**From:** Tim Townsend [REDACTED]  
**Sent:** 02 April 2026 11:26  
**To:** Williams, Chris; Hannah Kersley  
**Cc:** Blacker, Andrew; Steven Shaw  
**Subject:** RE: AL/11/24 - Land at Westergate - Follow-up points following today's meeting

**From:** Tim Townsend [REDACTED]  
**Sent:** 24 March 2026 14:04  
**To:** Blacker, Andrew [REDACTED] Williams, Chris [REDACTED]  
**Subject:** AL/11/24 - Land at Westergate - Follow-up points following today's meeting

SCALE @ A1: 1:500	CHECKED: JB	APPROVED: LRB
PROJECT No: 70013258	DESIGNED: GLG	DRAWN: GLG
DATE: September 23		REV: P04
LAW-WSP-ZZ-ZZ-C-DR-00007		
© WSP UK Ltd

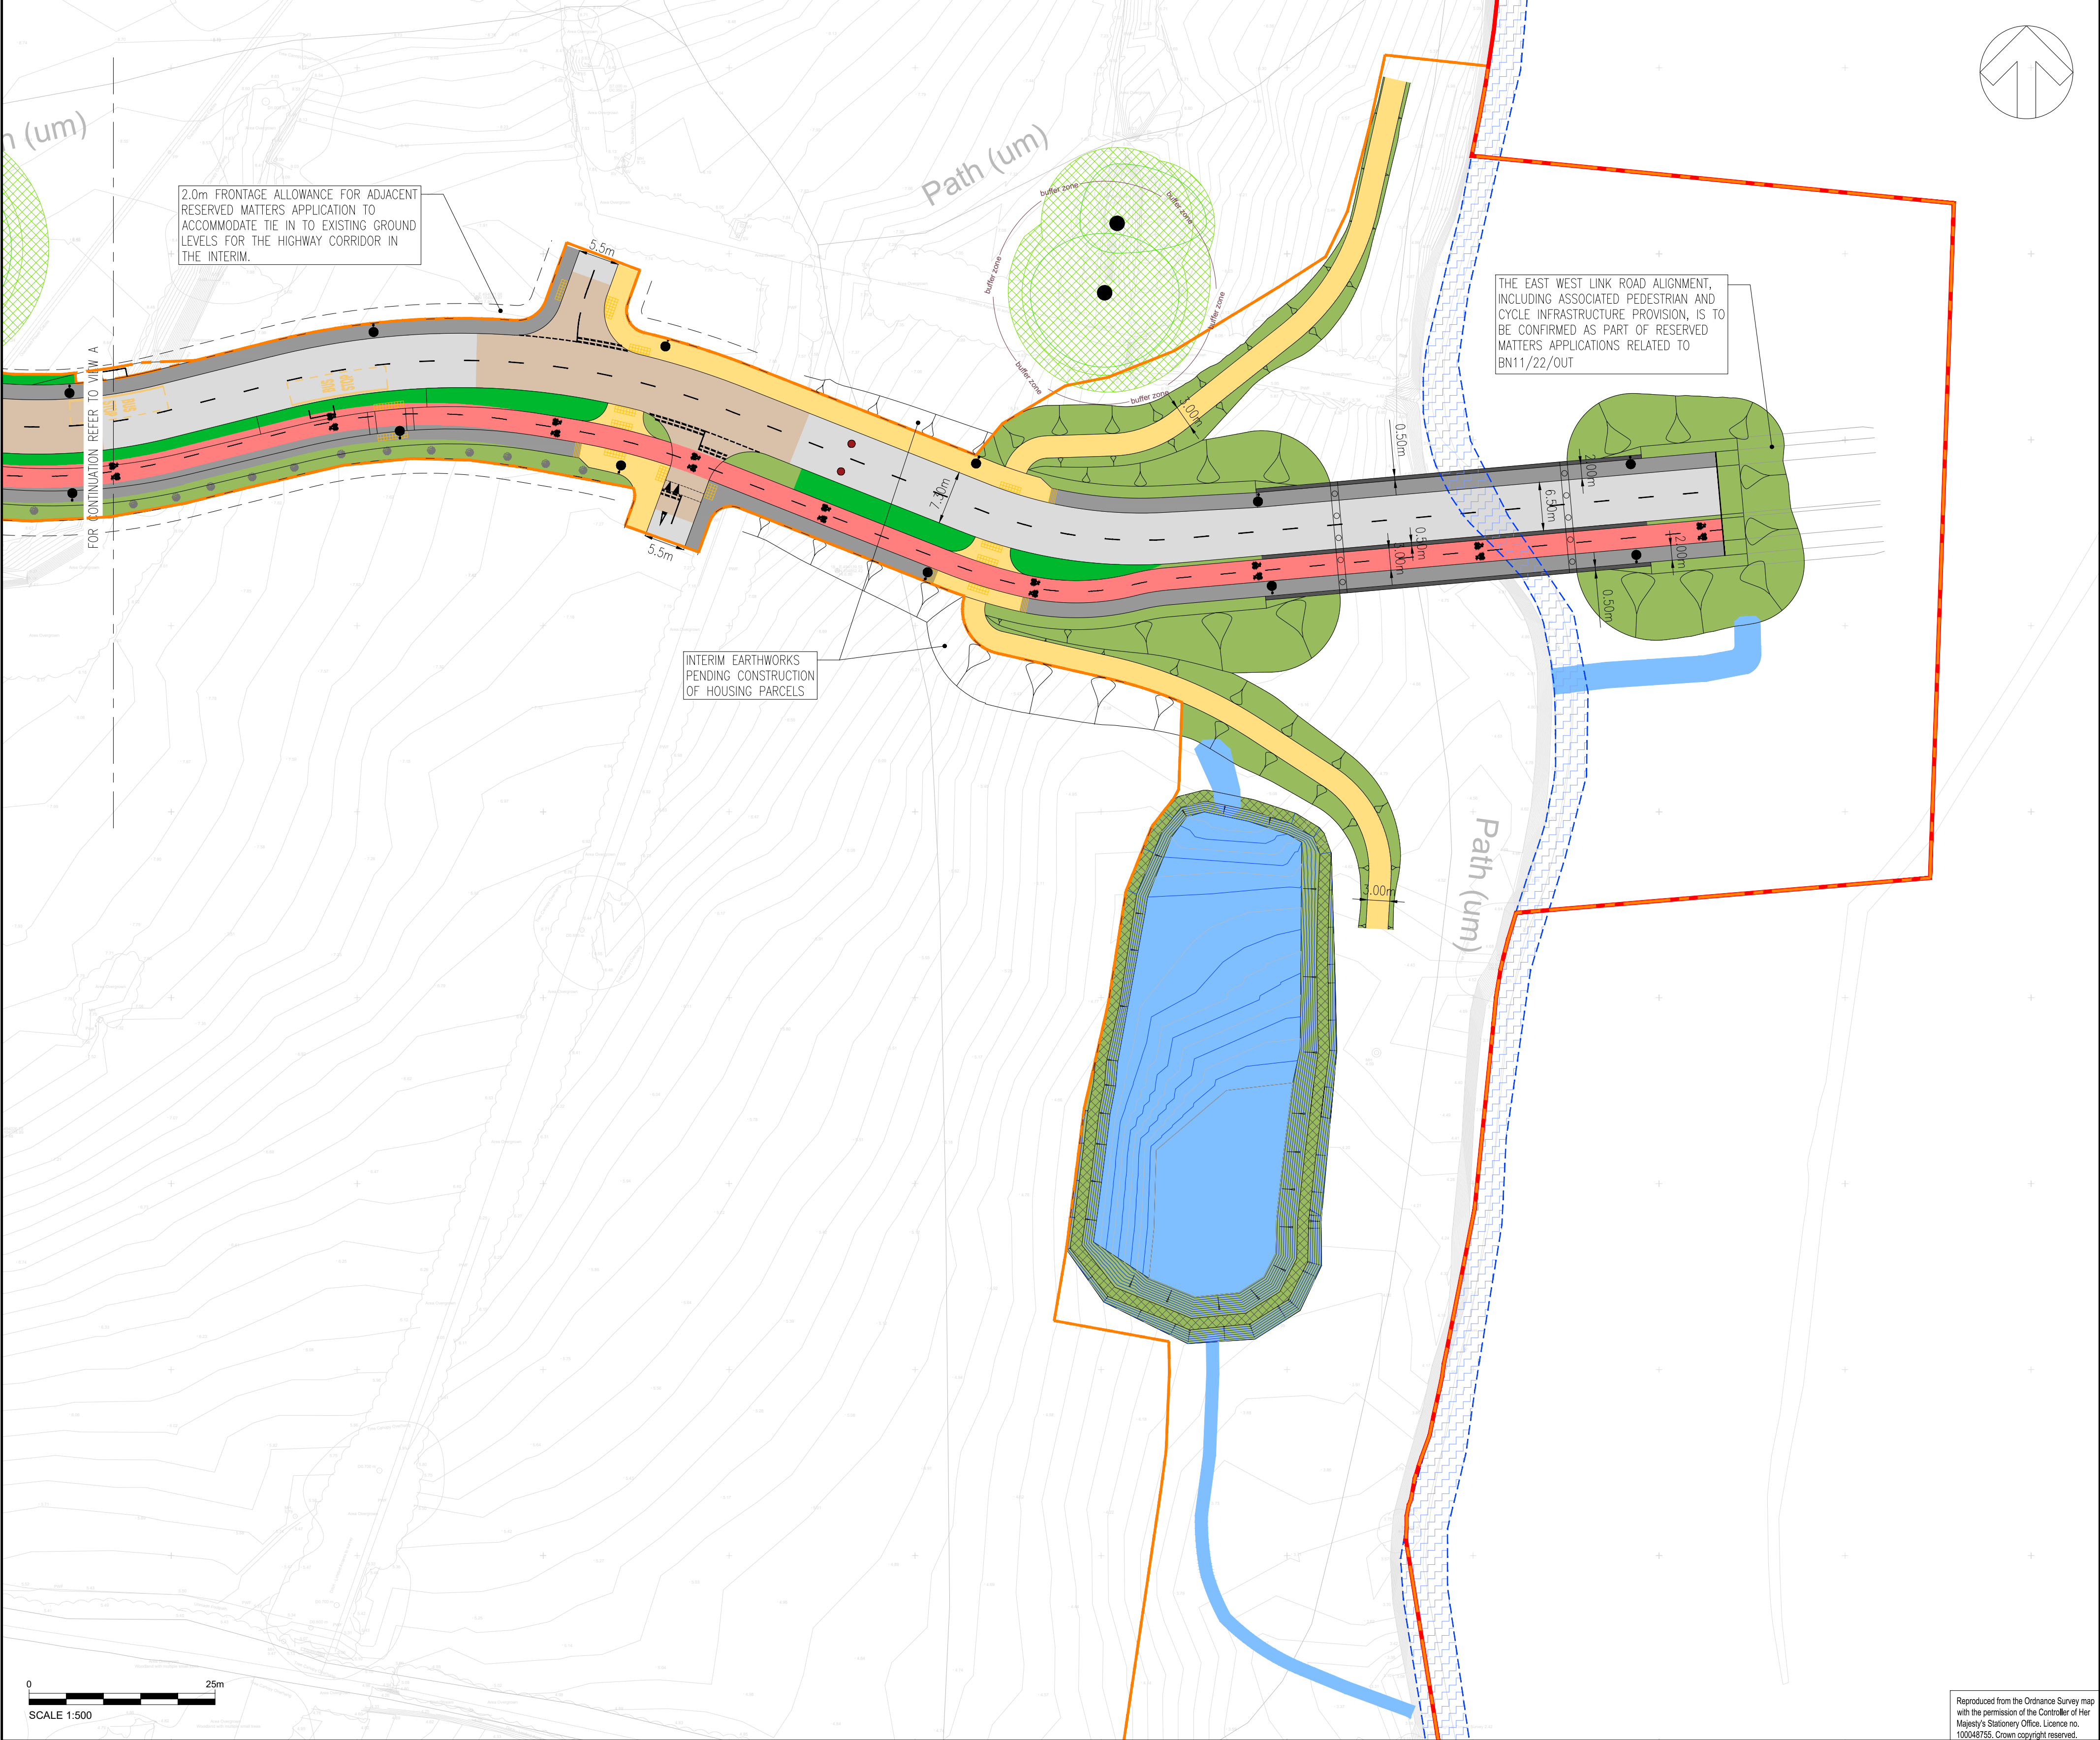
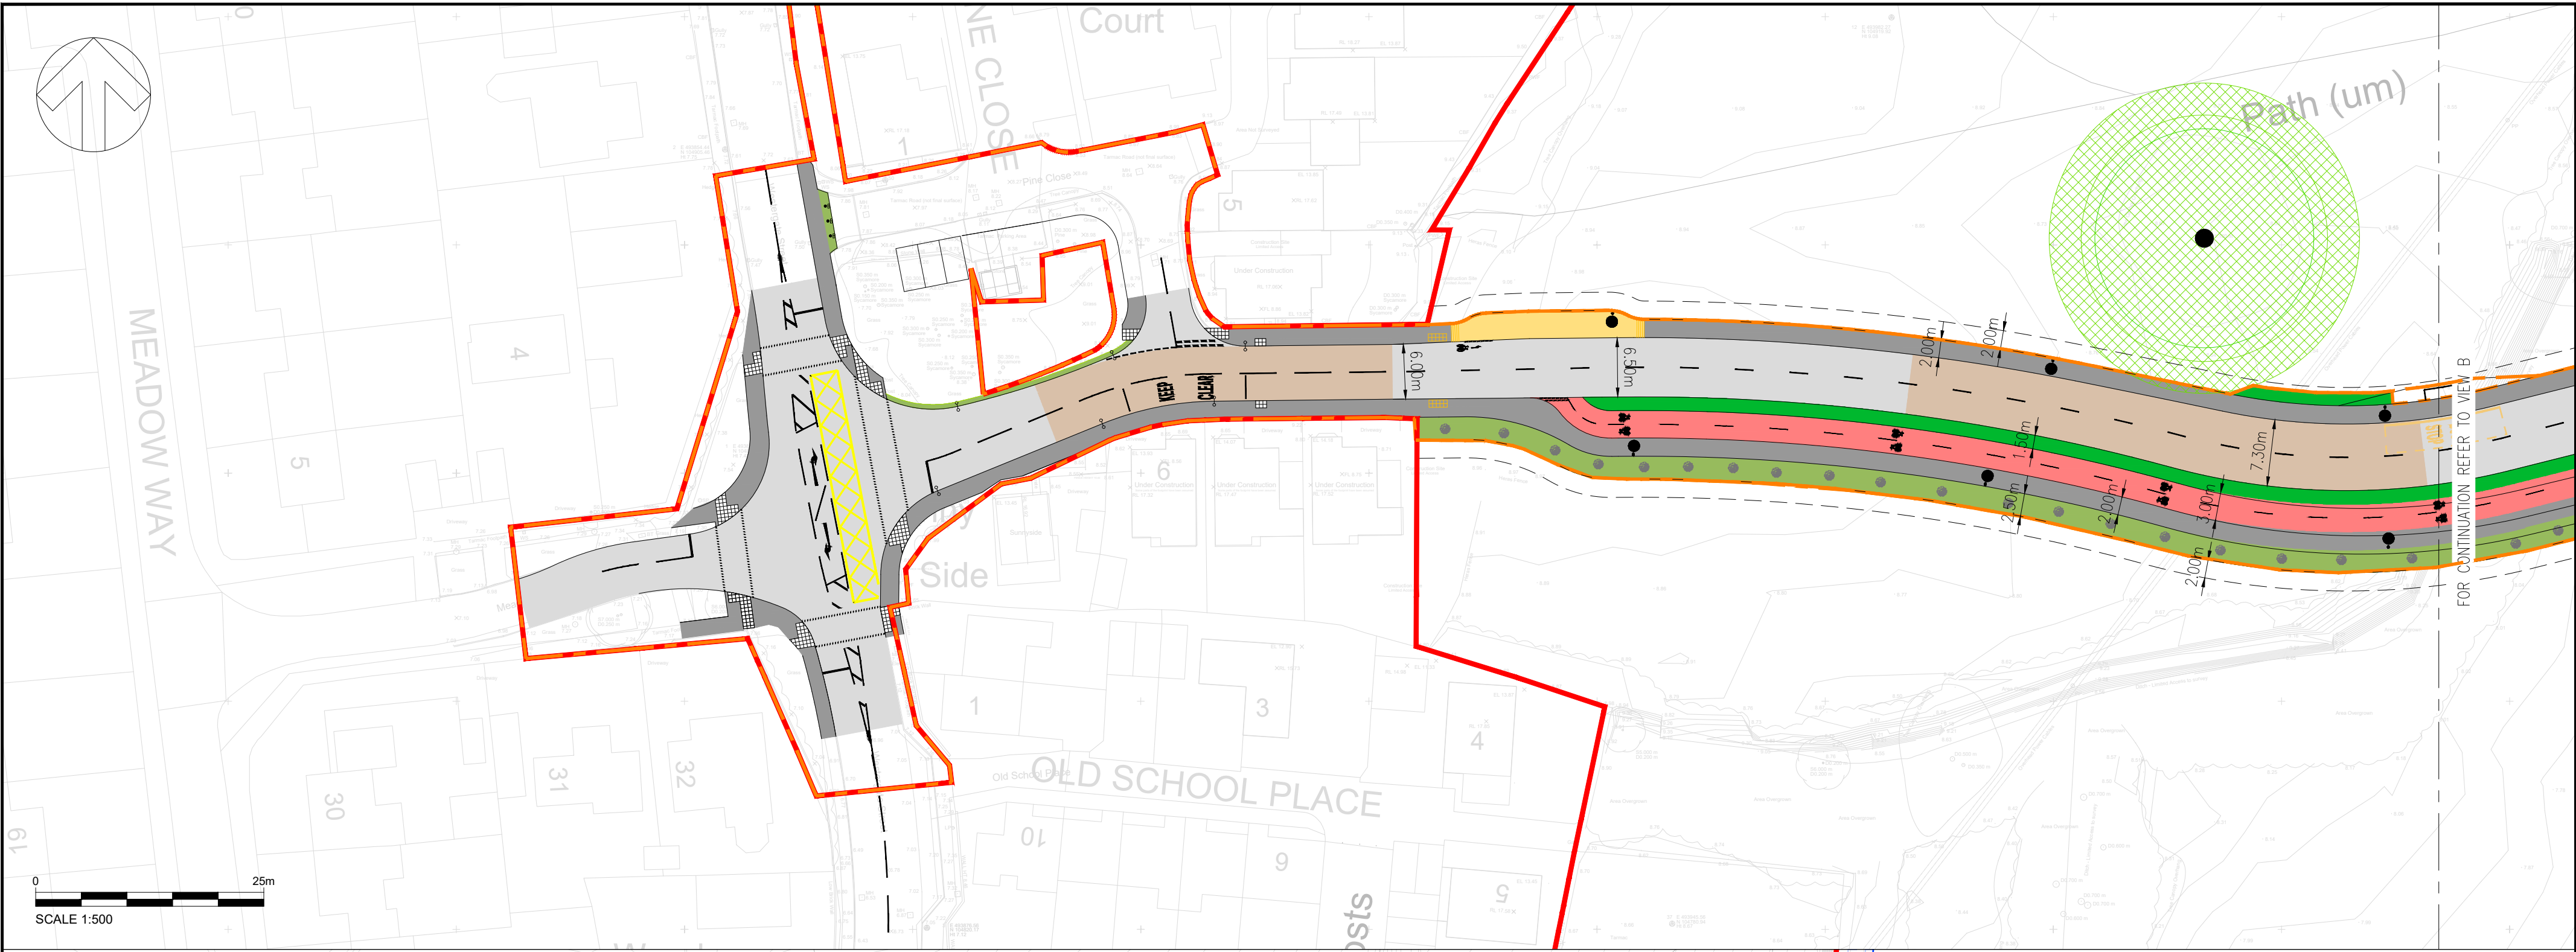
2. *Foot and cycle infrastructure on bridge forming part of E-W link* – Following today's meeting, I spoke to Hannah Kersley at Arun (the planning case officer) to (1) confirm that our meeting was very positive and that we are close to resolving final highway matters and (2) I spoke to her to find out her preference for bridge tie-in details with the Church Commissioner's land to the east. She said that given the detailed status of your client's site (and, therefore, the need to produce detailed plans) that all you would need to show is those latest drawings. She added that because the indicative drawings for the E-W link on the Church

Commissioner's land are just that – indicative – she said that the detail of those would have to follow as part of reserved matters submissions for their site and would need to be shown to interface with what you have shown. I will be pressing for the best solution for that site at the time those reserved matters proposals are made. However, for now, your plans should be sufficient. All I would suggest is for you to add a note to the effect that the ongoing design of the bridge and cycle and pedestrian facilities to follow from others (or words to that effect). And one final thing, please would you demonstrate that what you propose meets the requirements of LTN 1/20 with regard to dimensions, including kerb and verge spacings to/from the carriageway and 'scare' distance from parapet and 'live' traffic etc.
